Rezoning Transportation Analysis

Petition Number: 2020-075

Date	Description
07-23-2020	First Review
08-25-2020	Second Review

Current Zoning	(19.6 acres of R-3)			from Planning
Proposed Zoning	Townhomes	139 dwellings	1,010	Site Plan: 08-17-20

CONCEPTUAL SITE PLAN
REZONING PETITION #2020-075

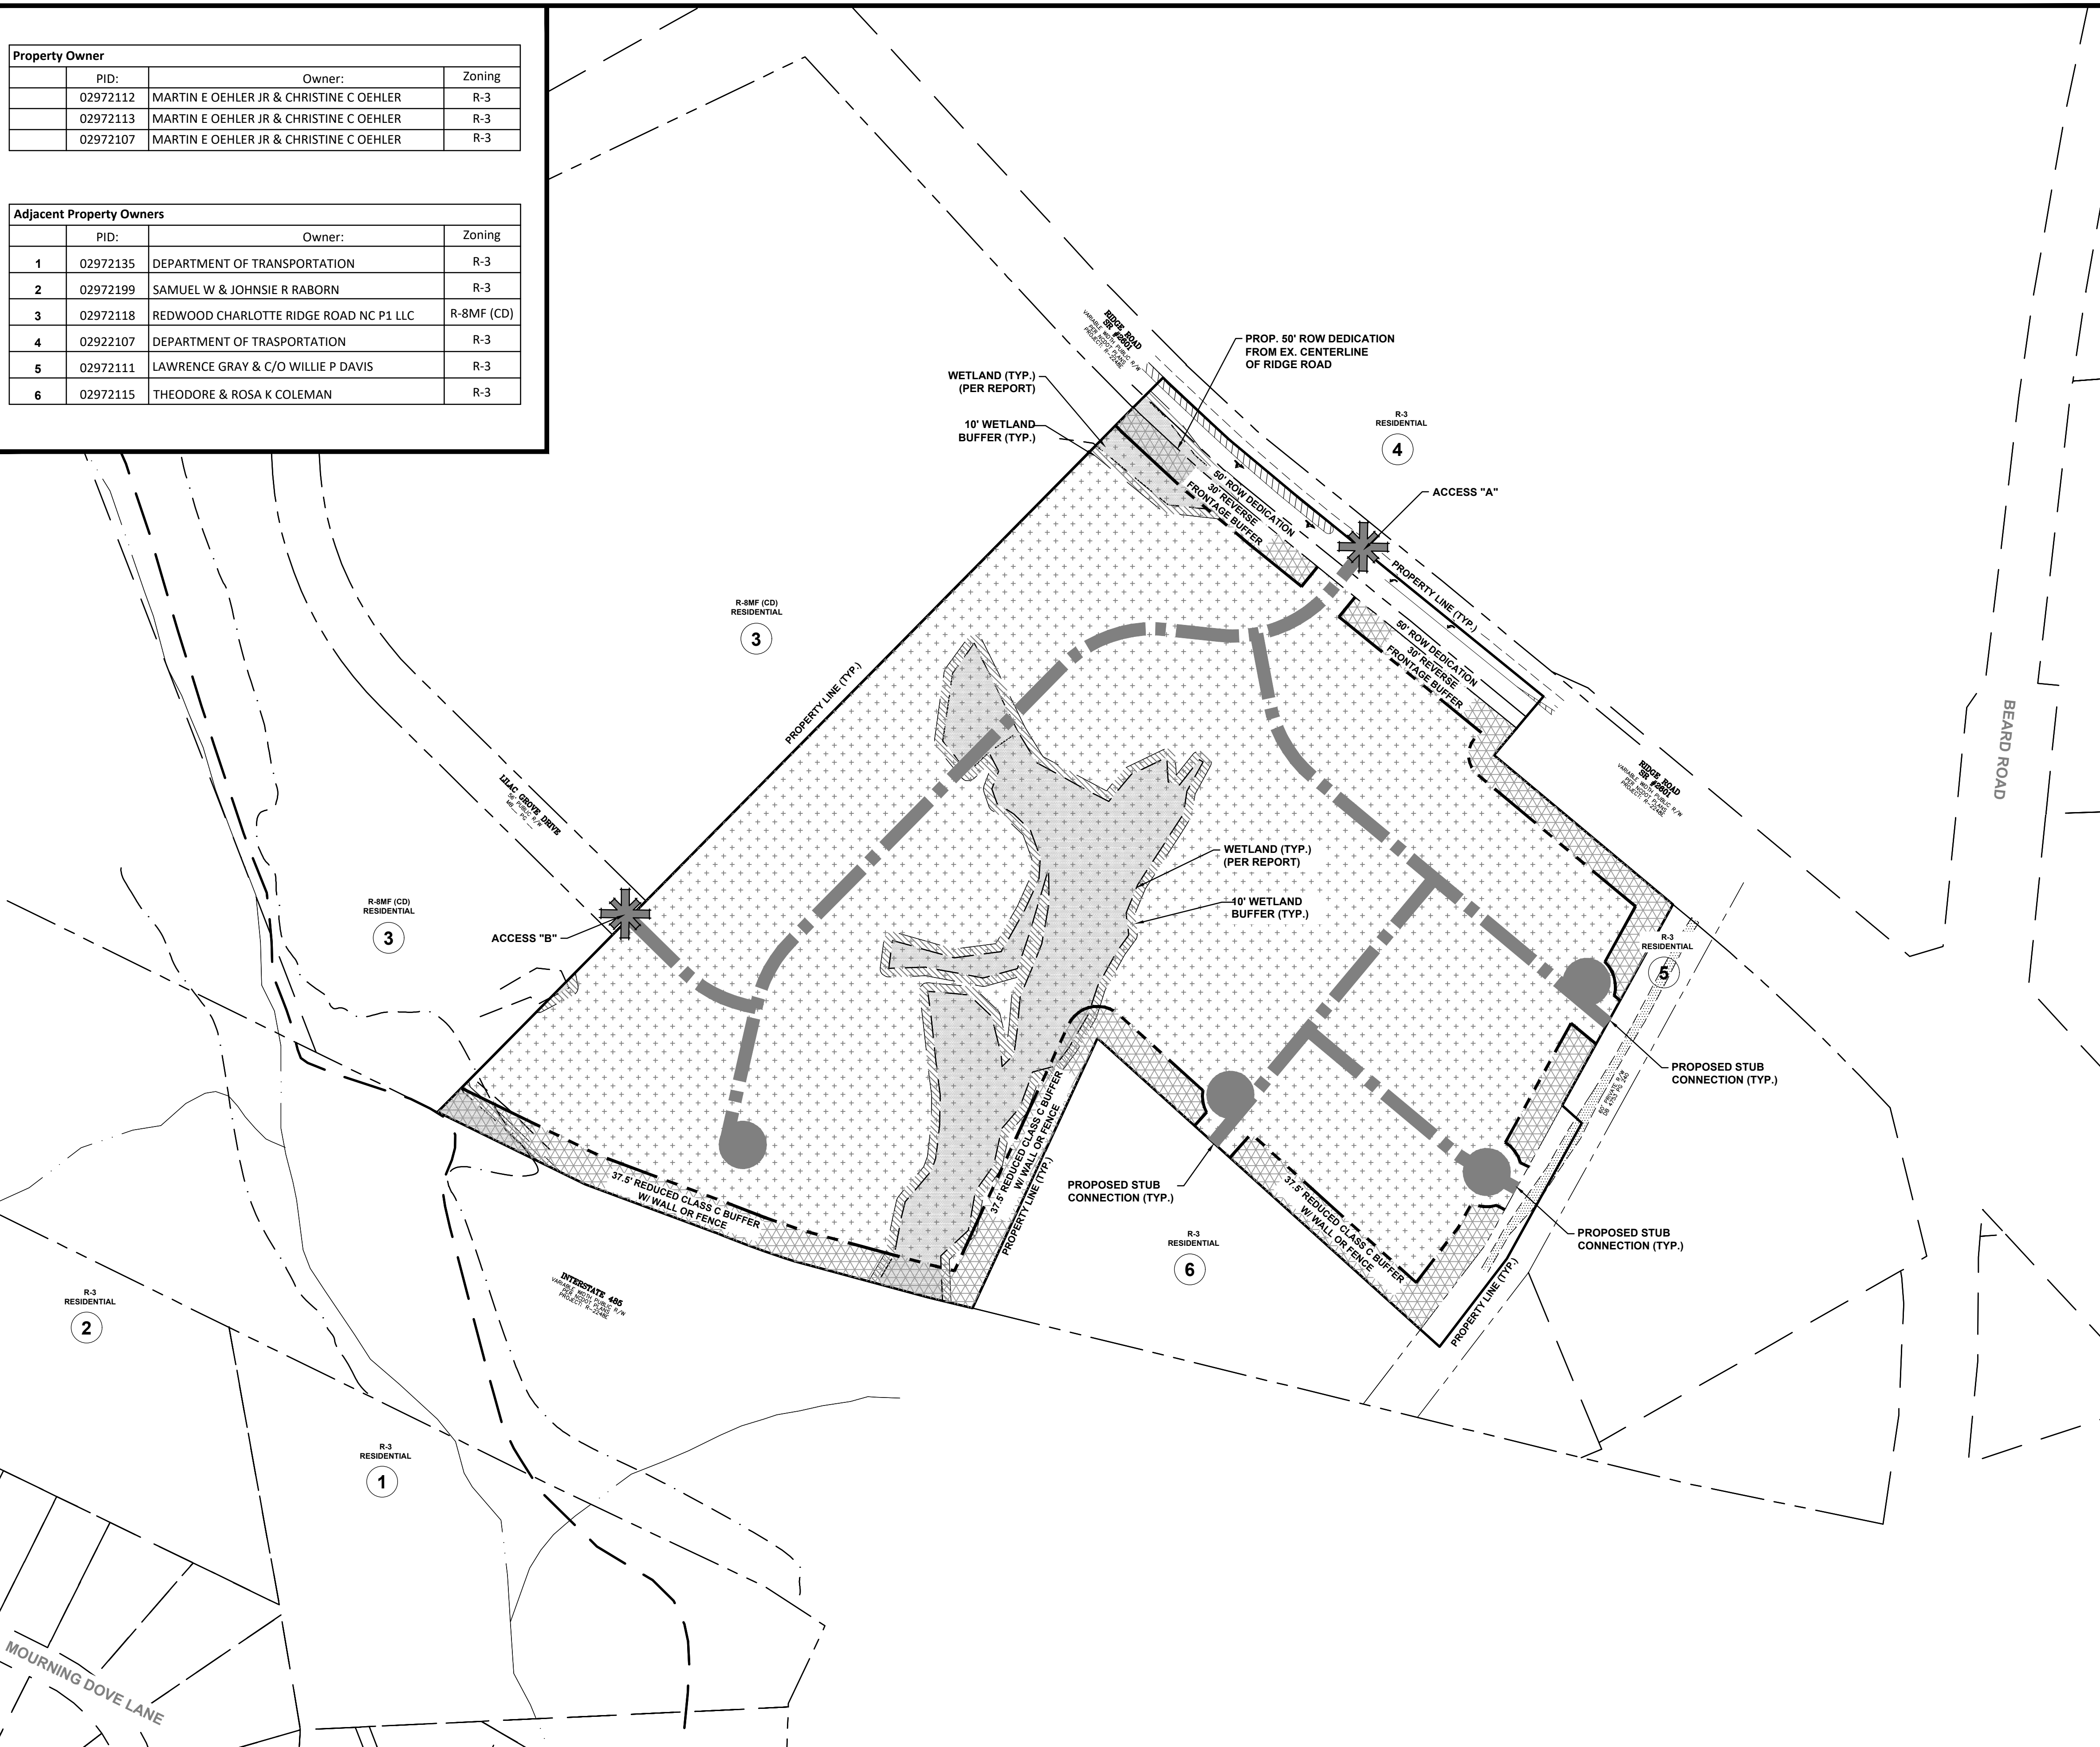
Ridge Road: The future location of curb and gutter should be reflected to match the Prosperity Hucks Area Plan cross section, as shown below. Pavement widening should occur asymmetrically to the south of the proposed petitioner's site, since the parcel across Ridge Road to the north is a mitigation site for I-485 construction and is protected by a conservation easement. Please refer to **SDRMFR-2019-00041 - Redwood Ridge Road** to tie-in the proposed streetscape into the approved Redwood Ridge Road subdivision plans.

The site plan should show the curb and gutter labeled and dimensioned from the centerline for each road.
